Re: **Application number 2019/90269** ADJ, 93 STOCKSBANK ROAD MIRFIELD
WF14 9QB ERECTION OF DETACHED DWELLING AND ASSOCIATED SITE
WORKS

We wish register our **objection** to this Planning application.

Stocks Bank Rd (20)001 /
Proposed GA

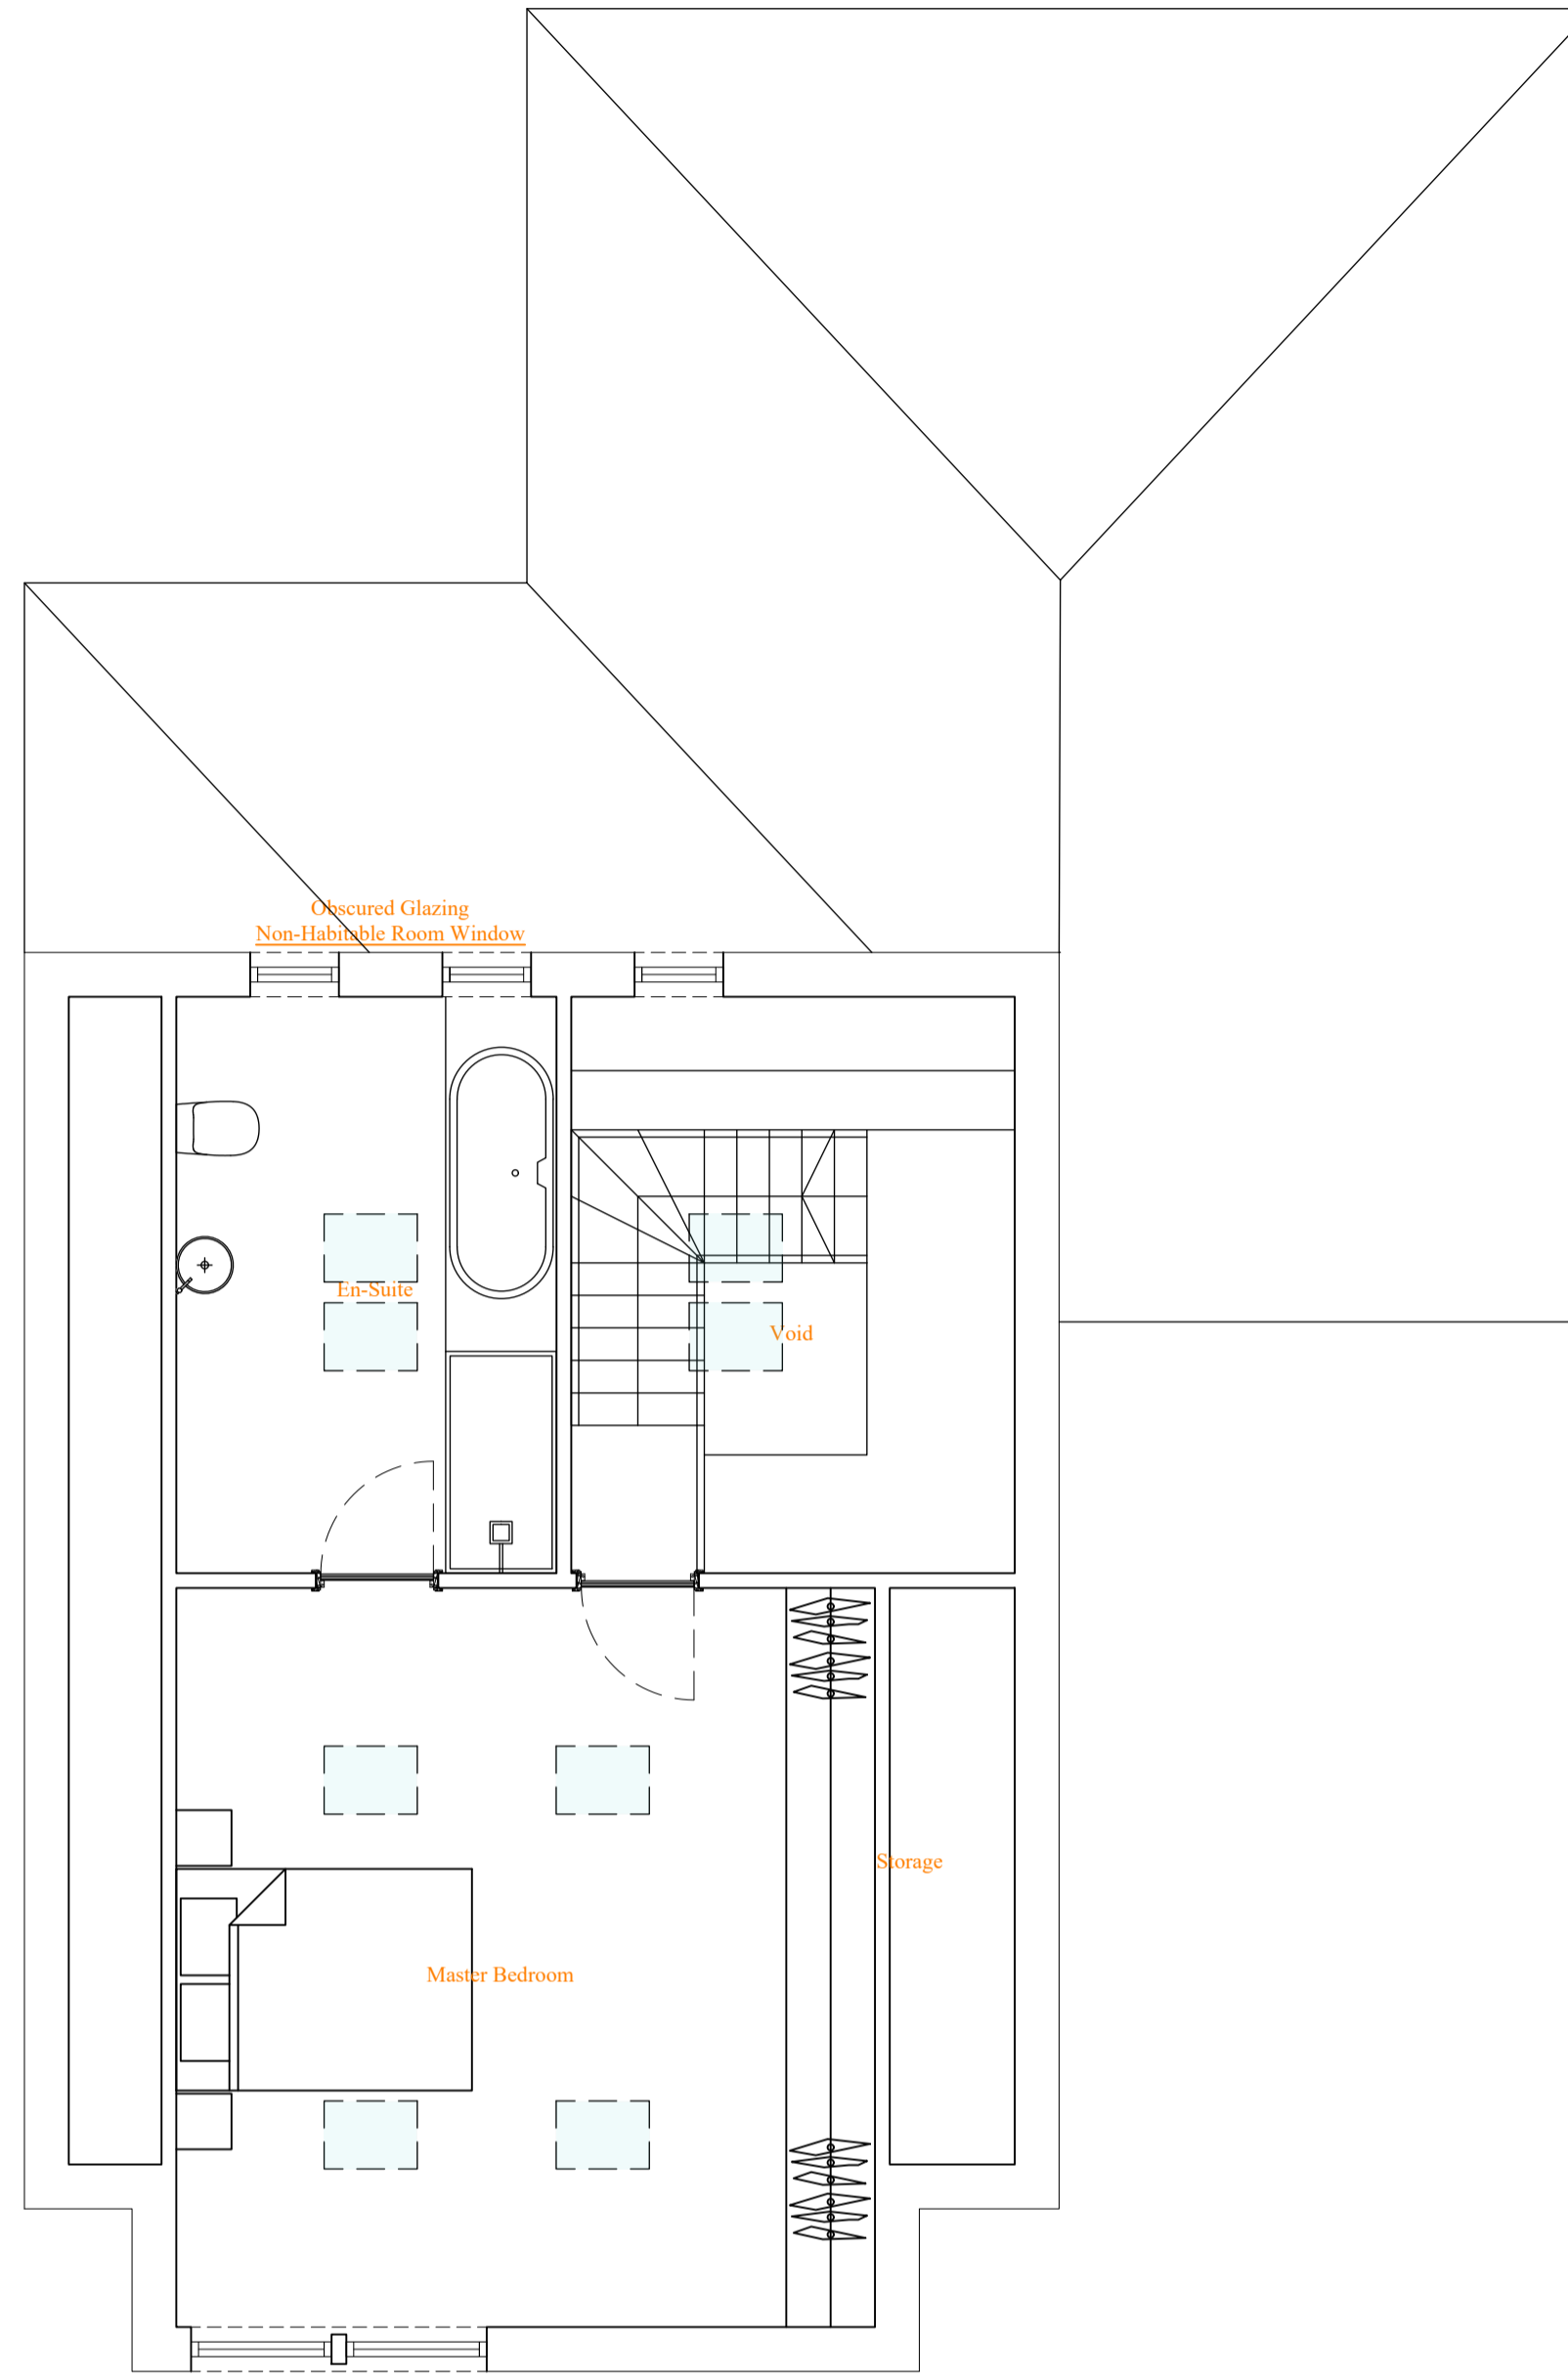
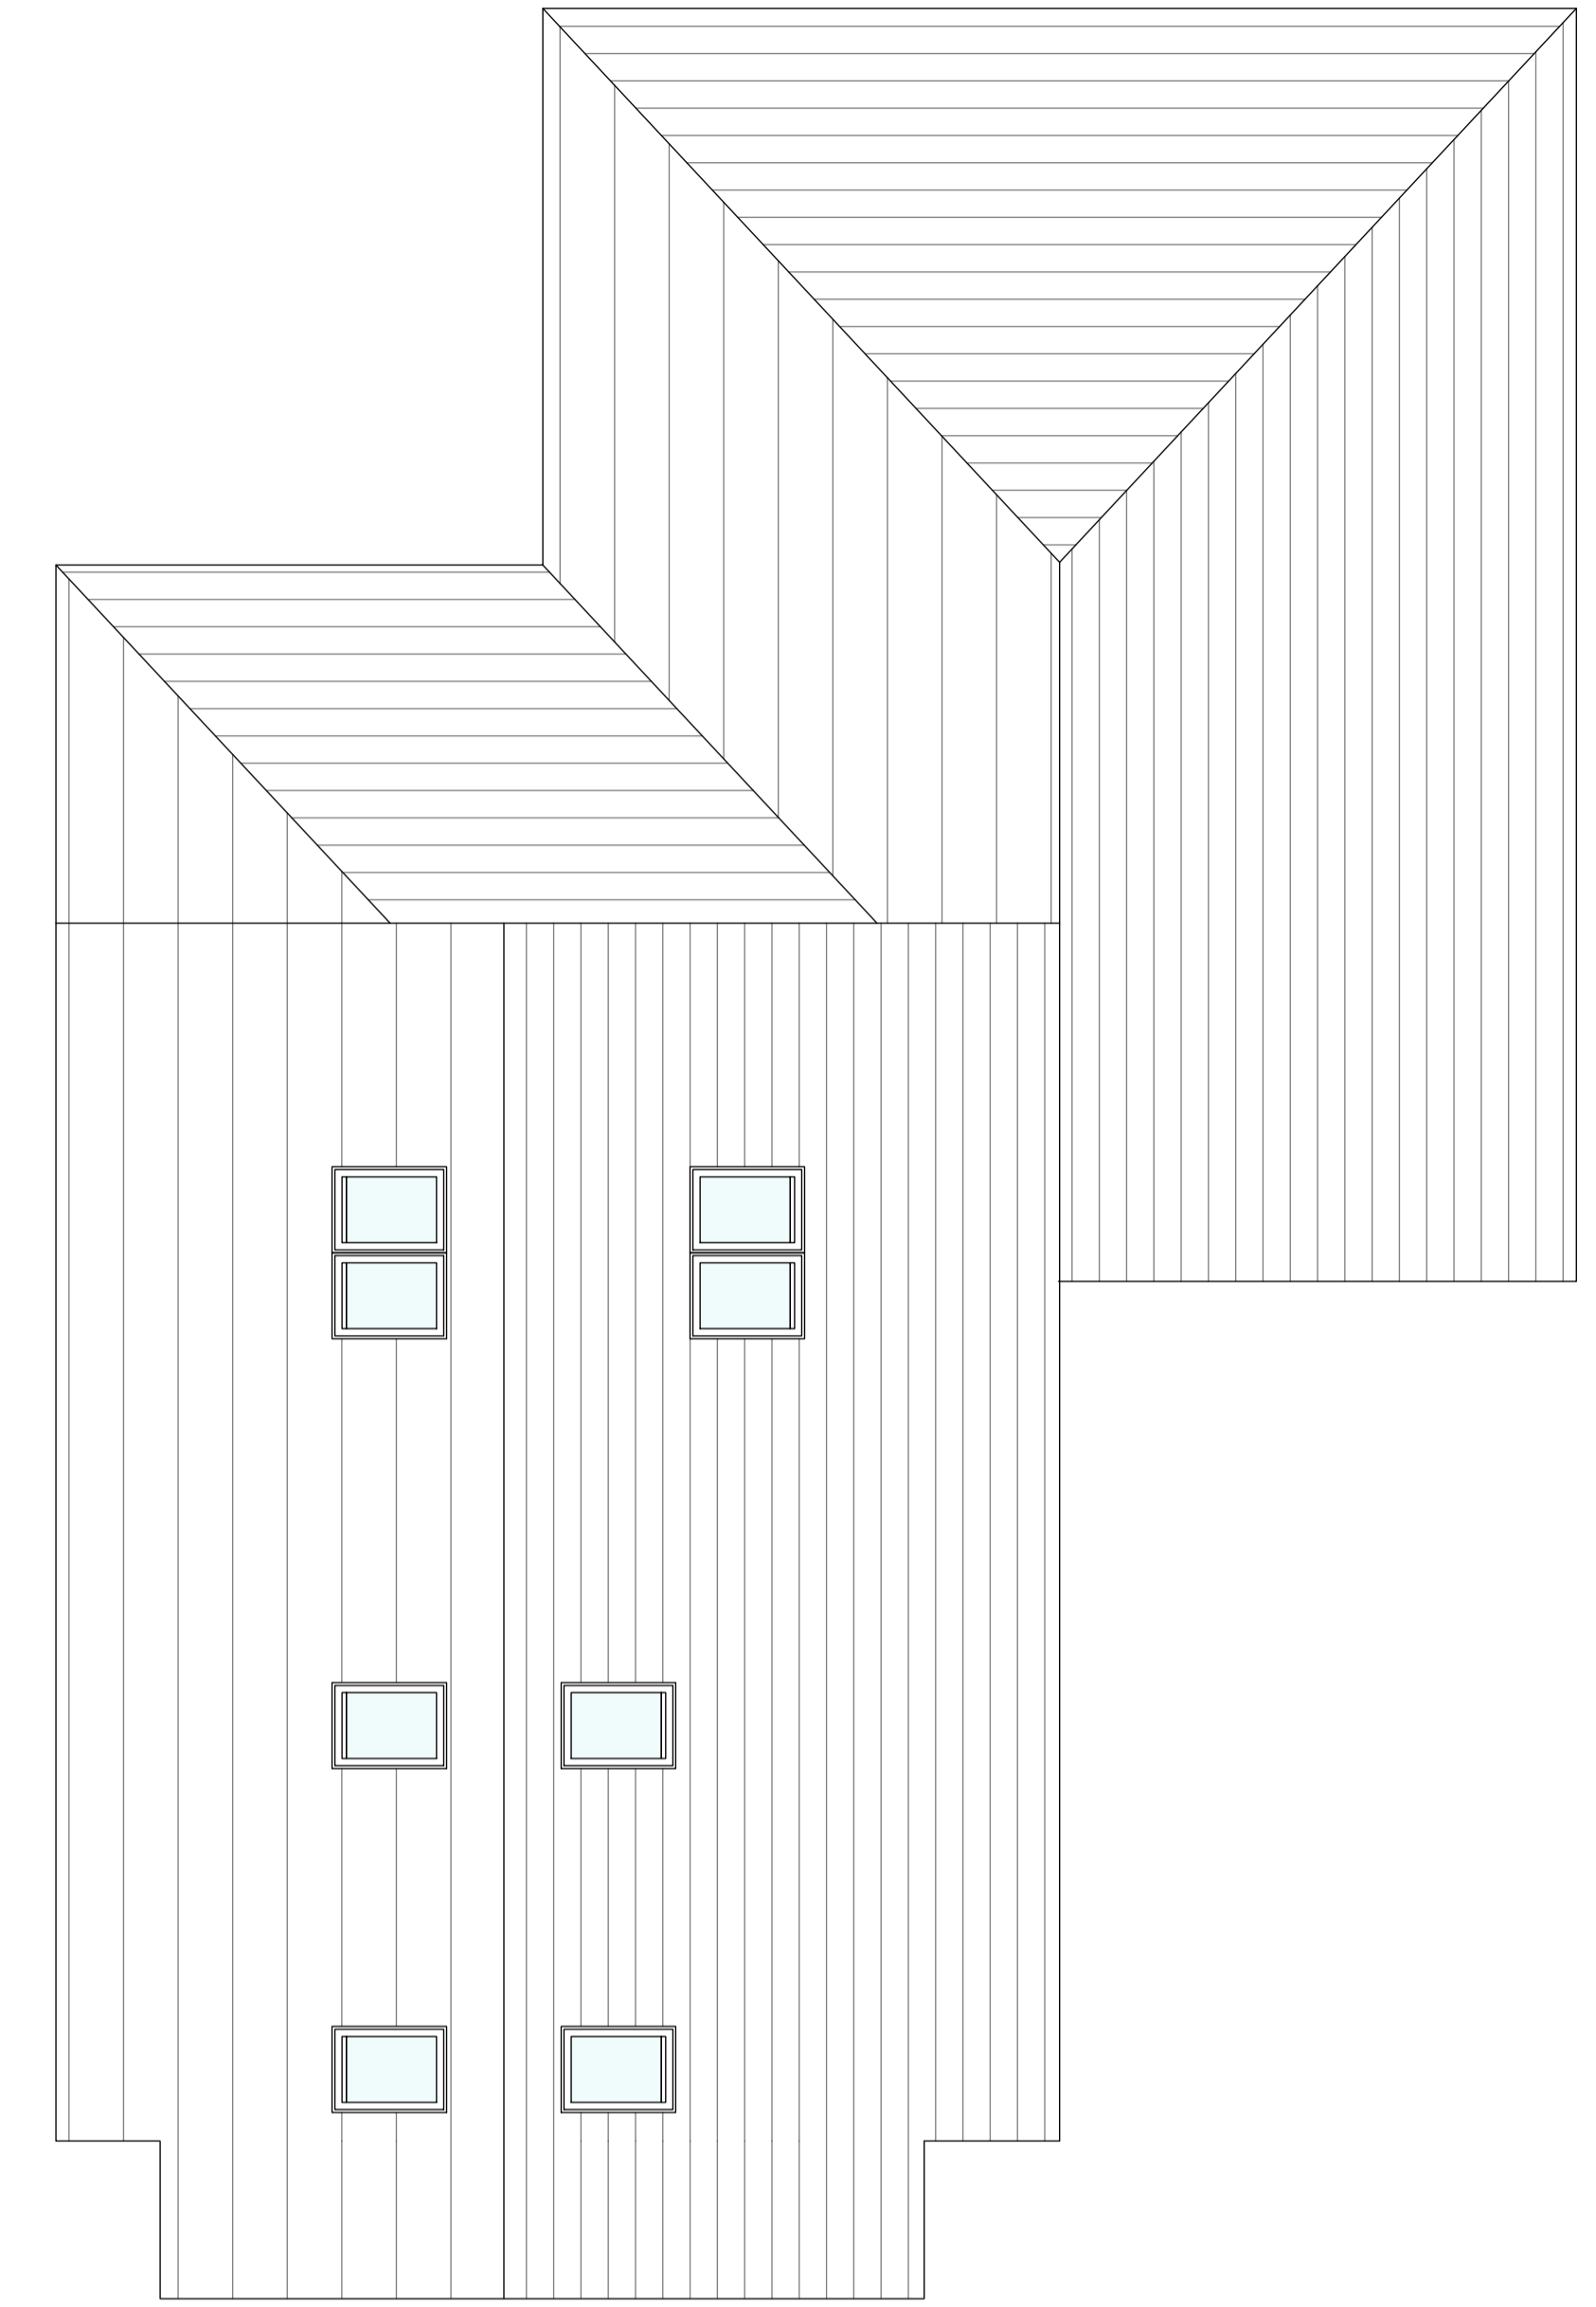
There are inconsistencies between the various plans supplied for the project such as roof lights on the former garage area on some plans and not others. The living room window to the rear is shown as a door and as a window.

The distance window to window of the rear bedroom of the proposed building to the existing 1st floor window on the gable of 1 Ford Drive is measured off as 17.129m which is below the recommended BE12 distance of 21m for occupied rooms. Whilst this is at an angle between the windows with the window at 1 Ford Drive being at first floor level, it will be possible to look down in part on to the window in the proposed building. In the summer months some screening may be provided by the cherry tree if it remains in situ.

The statement mentions that there are to be no habitable room windows in the rear elevation of the existing garage structure which is being used to form the main living area of the new house. Whilst this is in accordance with the Planning Inspector's comments, can this requirement be guaranteed and enforceable that no windows or constructions e.g. conservatory, raised ground level, decking, reduction of boundary height and so on, can be installed in the future by the applicant or by future owners?

It is noted that the front of the former garage area is to be extended some 2.3m further forward towards Stocks Bank Road. As the extended garage is at an angle with the site boundary to no.93a, is the minimum distance to this site boundary, which is understood to be 1.5m, being achieved?

The proposed property will occupy virtually the full width of the plot of land, leaving only a 1.4m gap between no. 93 and the proposed new build. There also appears to be a roof overhang of no. 93's guttering over the plot of the proposed new dwelling, is such a roof overhang onto neighbouring property allowed within the Planning Regulations?
